Comments on "THE RANCH" from Judy von Ahlefeldt per the plan revision after Meeting 1 presented in March, 2019.

LAND USE TABLE

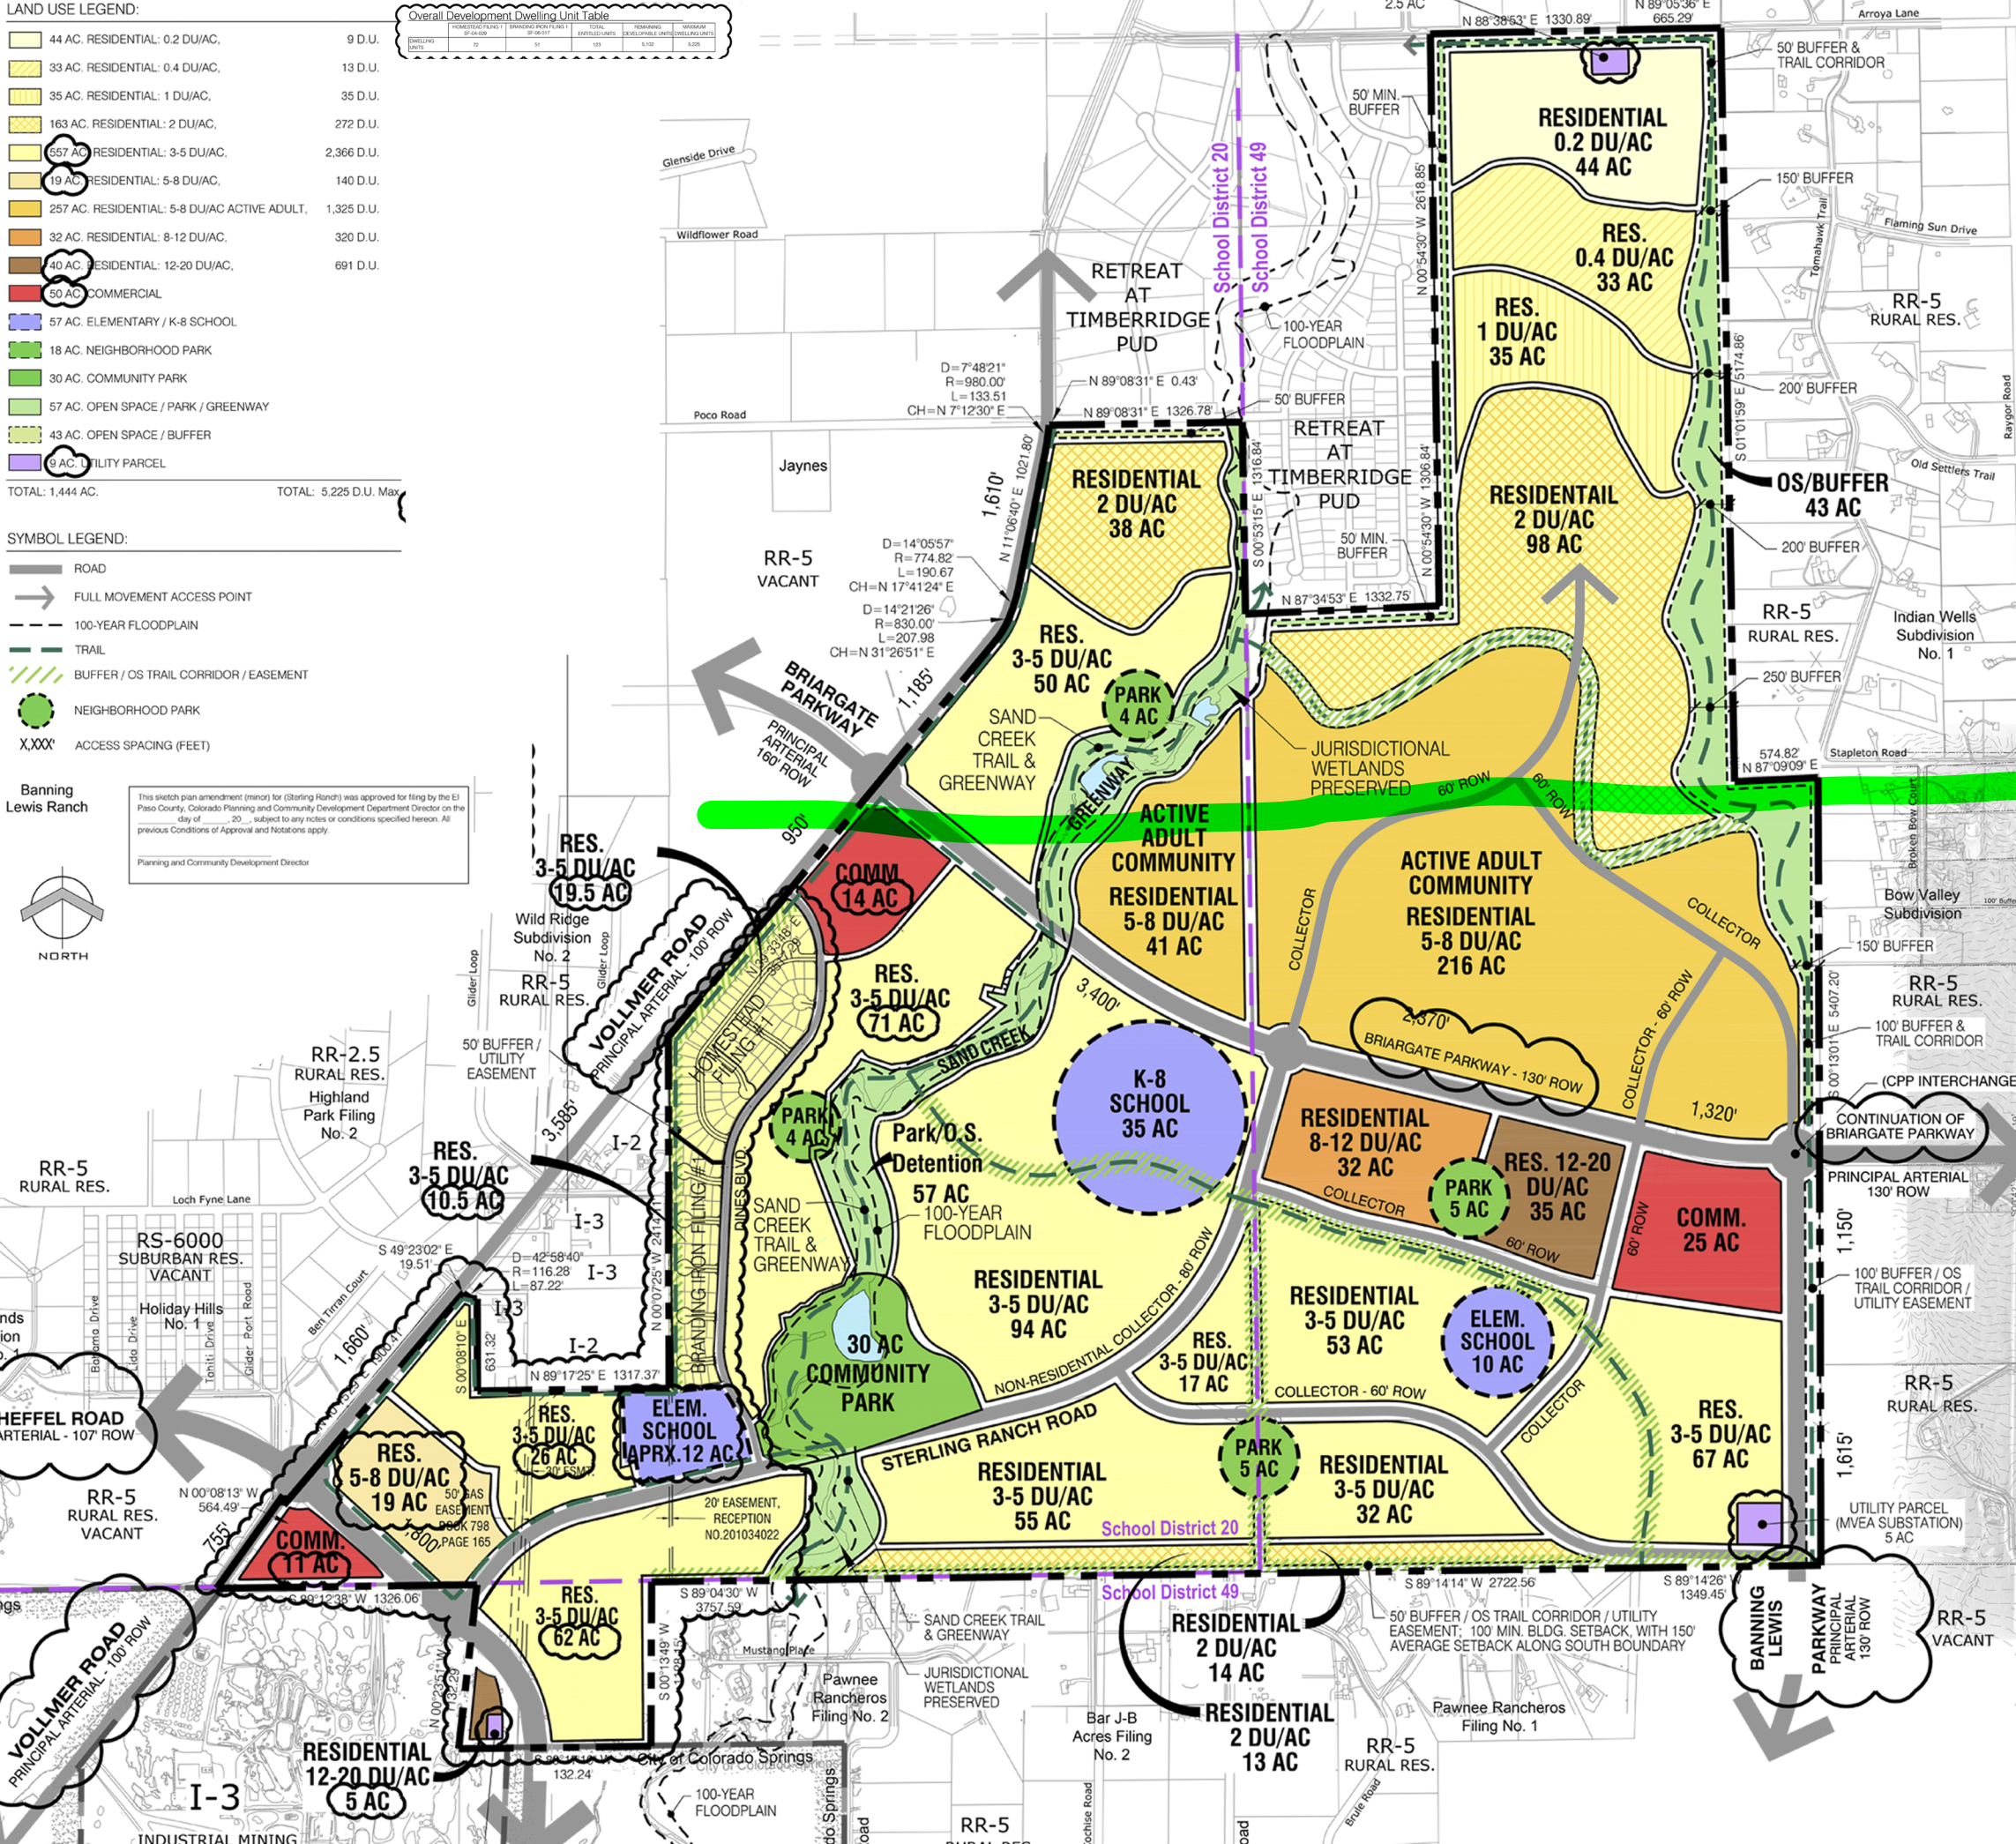
- Do not put highest density near the church and north of Stapleton. Better to put it next to the school to the east.

- Widen buffers (200') on N, west, south; 300' under Excel line on east
- Extend Bow Valley buffer to Stapleton on West; add buffer to south property line on West.
- Buffers provide transition, open space noise mitigation, room for antelope to move, and place for Prairie Necklace Trail is this subdivision.
- Widen area for internal trails along wetlands and restore those wetlands (willows and cottonwoods)
